**Application Number:** SSD-30759158 - Minarah College

Upon reviewing Martens Drawing No. PS01-E100 revision B, I strongly oppose this project.

A1 / A3 LANDSCAPE (A3) v02.0.01												PROJECT NO. P2108320	PLANSET NO. PS01	RELEASE NO. R02	DRAWING NO. PS01-E100	REVISION B

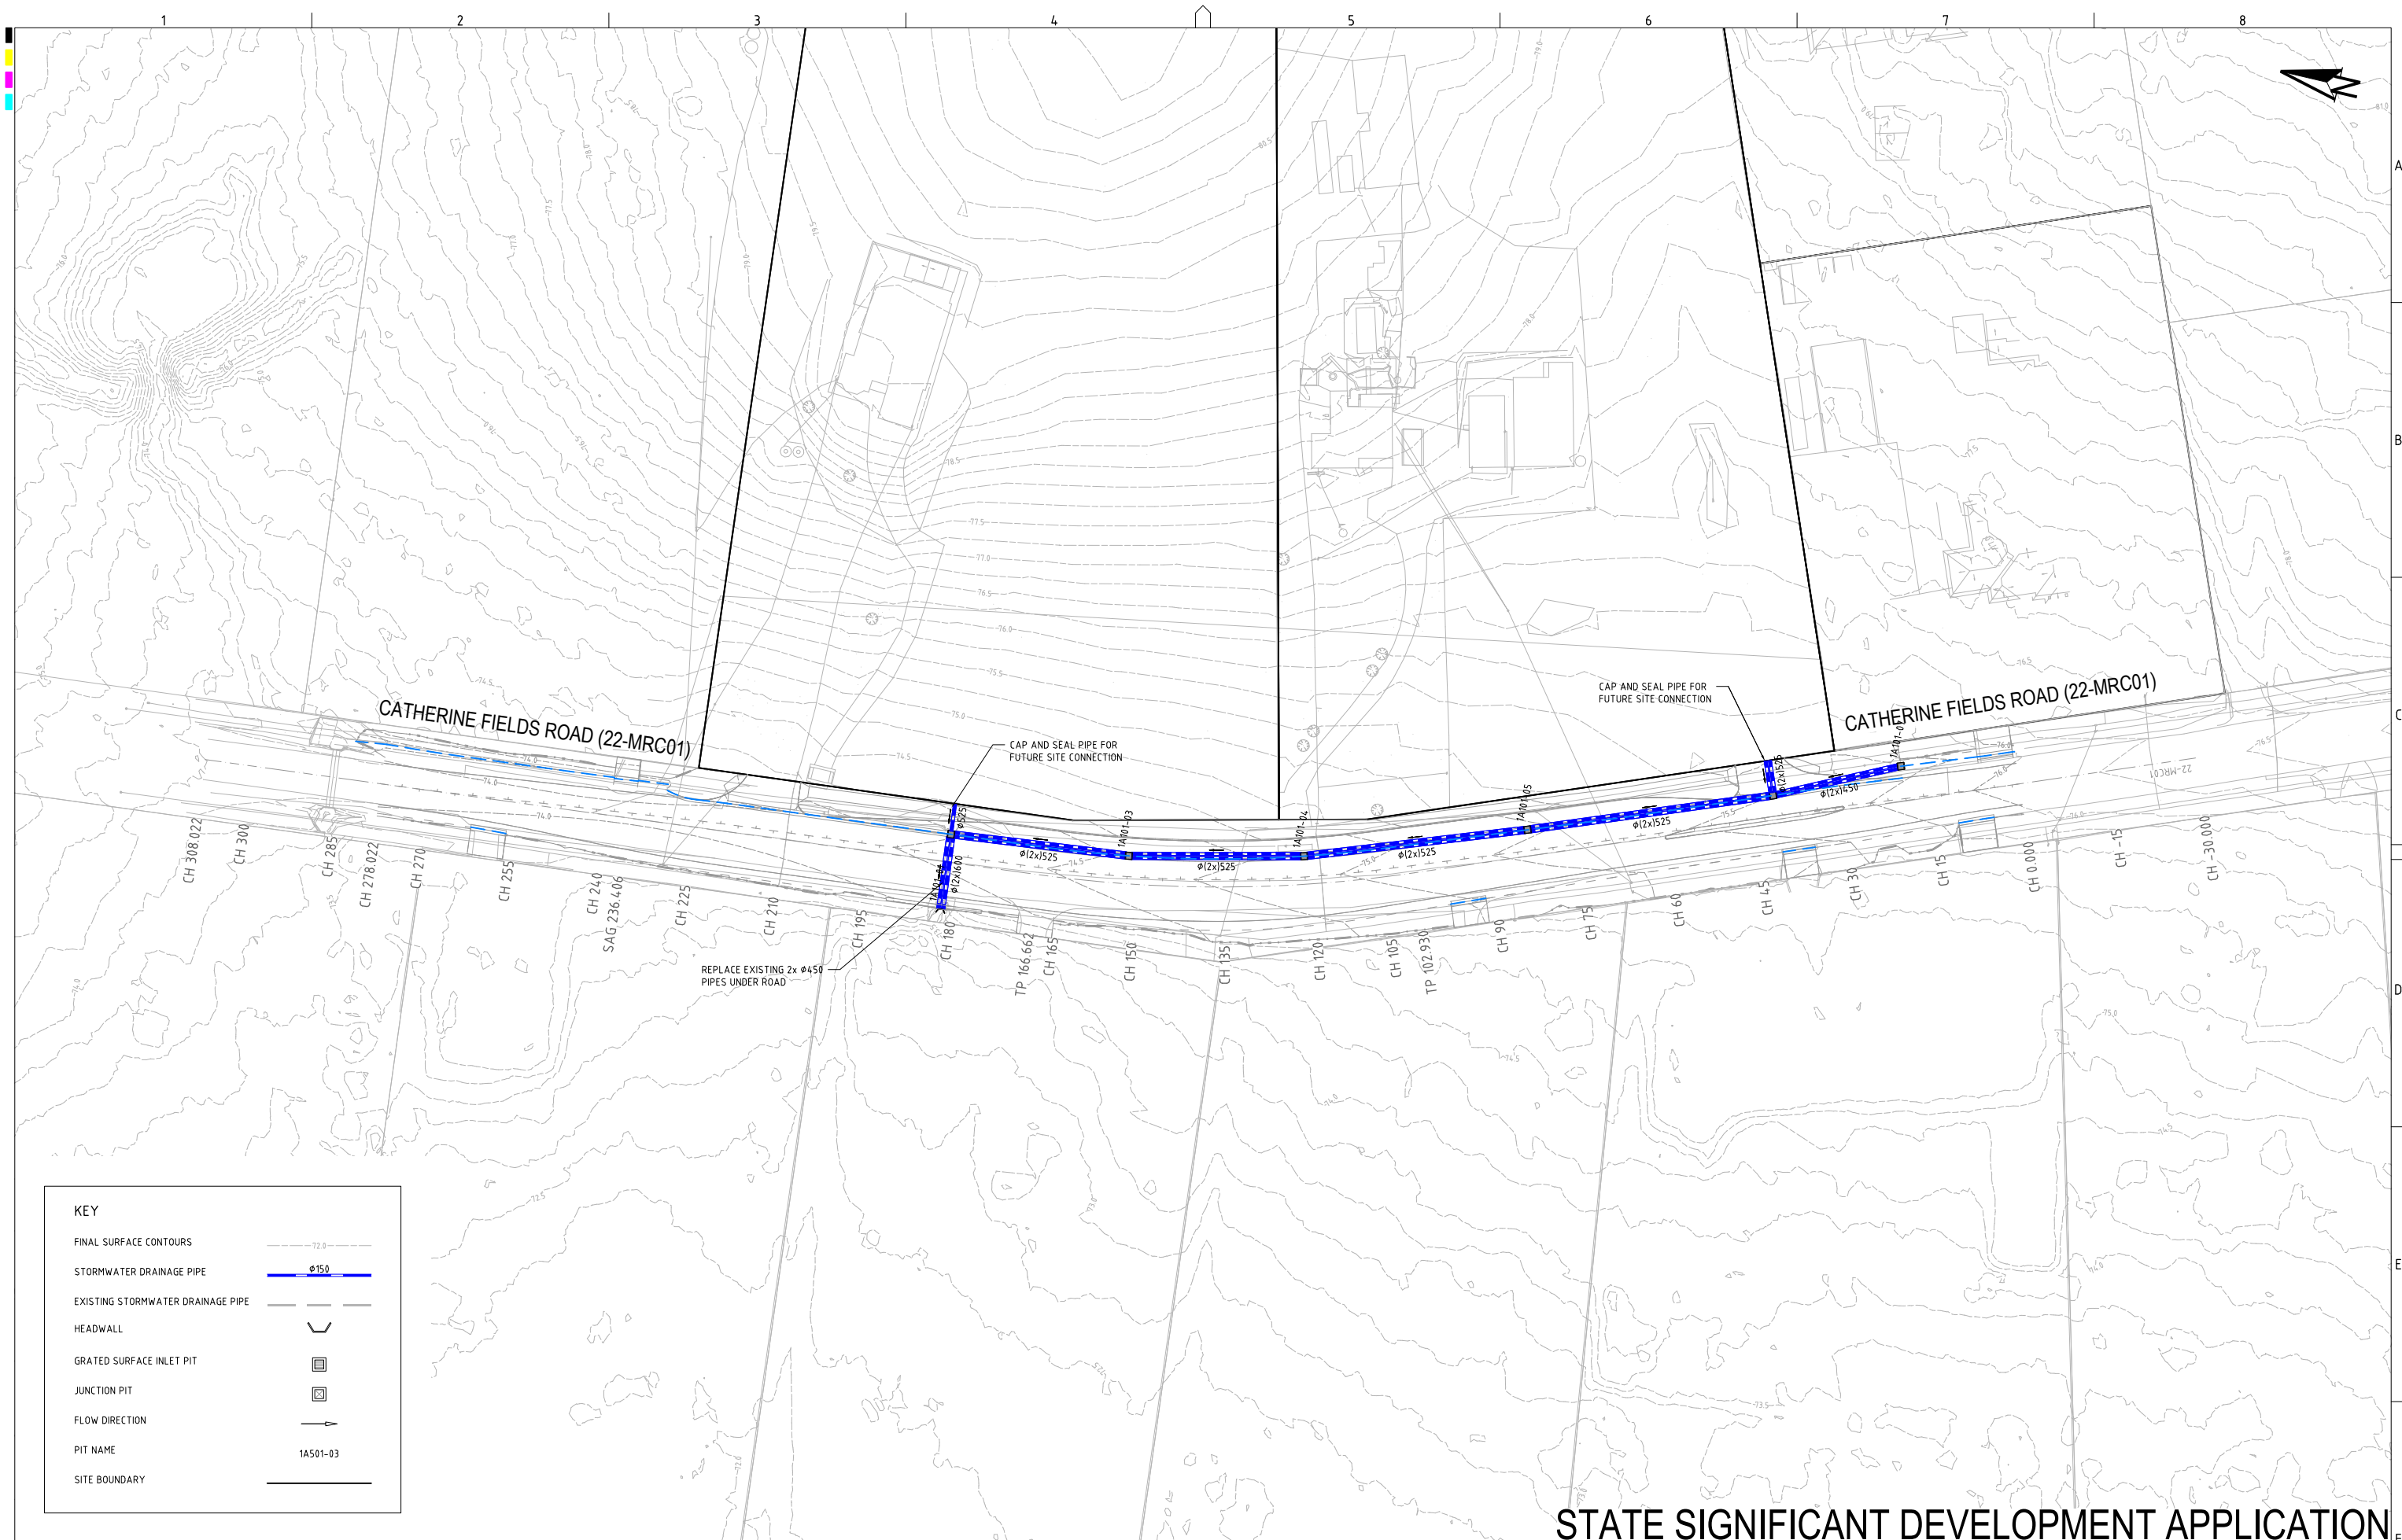
The fact that the proposed installation of two new stormwater drainage pipes will be installed under Catherine Fields road will most certainly increase the flooding of neighbours at 277 Catherine Fields road and 285 Catherine Fields road which already are impacted during times of heavy rain.

I see no evidence of communication with Camden Council, considering they have ownership of Catherine Fields road, for approval of these works to be carried out.

I see no evidence of communication with these residents in the planning documents or plans to seek further consultation to remediate this concern.

I would suggest that Martens conduct a thorough walkover of the properties during heavy rainfall and examine for themselves that amount of water that flows from the overland flow of 268 Catherine Fields road and re-submit an accurate report.

This directly does not meet the requirements of SEARs 13 and 14.
